PL207-2018 222 St John St - MMC Parking Garage: Street & Streetscape Preliminary Comments

The following are my Preliminary Comments on the plans (dated 6/22/18) for the proposed MMC Parking Garage. Additional comments are likely.

BRICK SIDEWALK DETAIL
N.T.S.

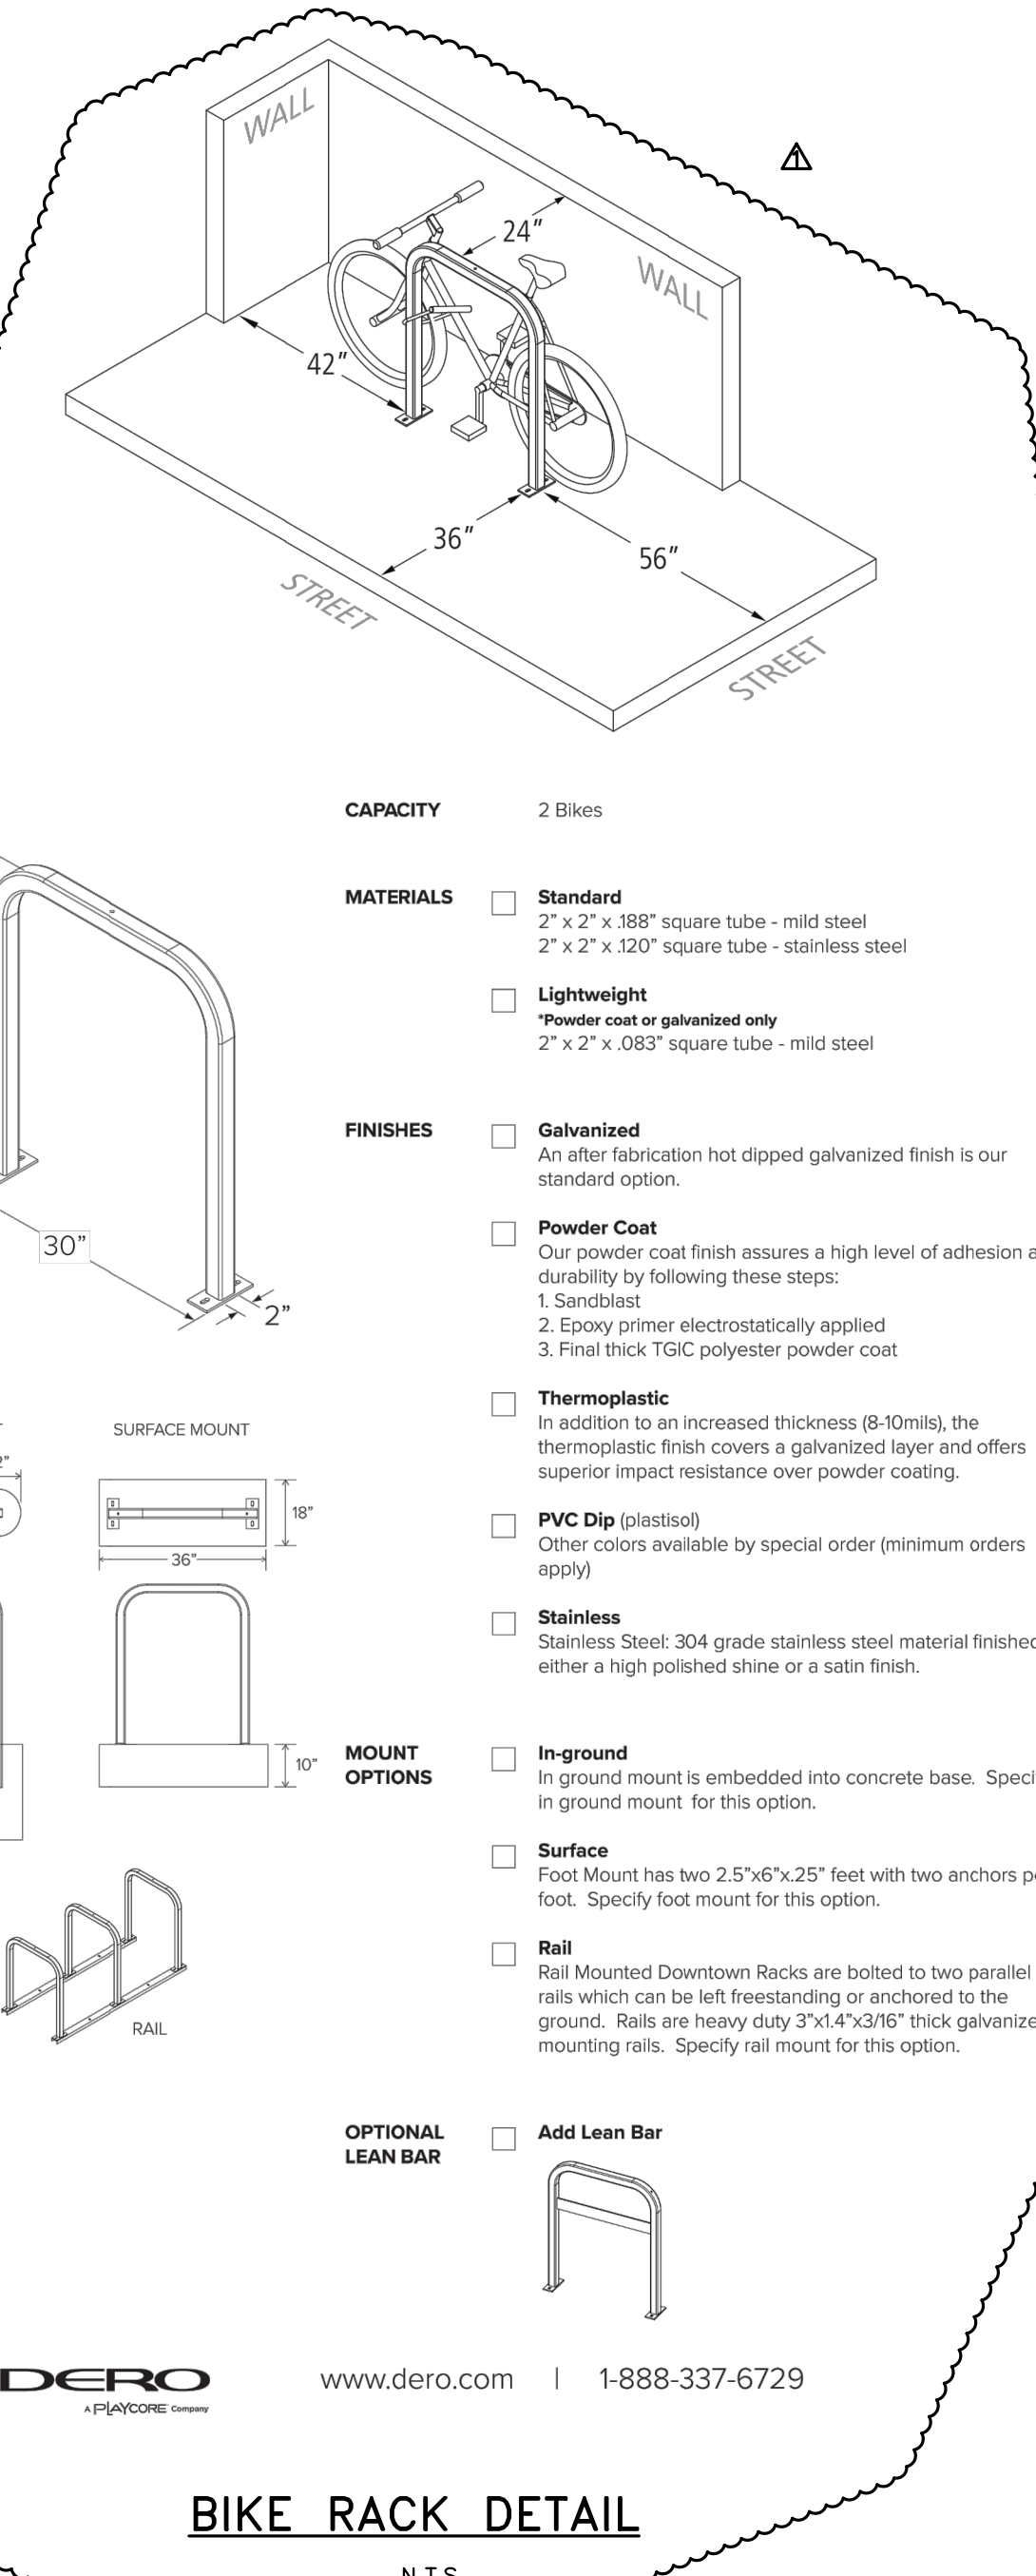
- The Brick Sidewalk Detail is to be modified to state "2% cross slope (MAX.)" not (TYP).
- Details are needed for Detectable Warning Panels (cast iron) and Driveway (showing "2% cross slope (MAX.)")
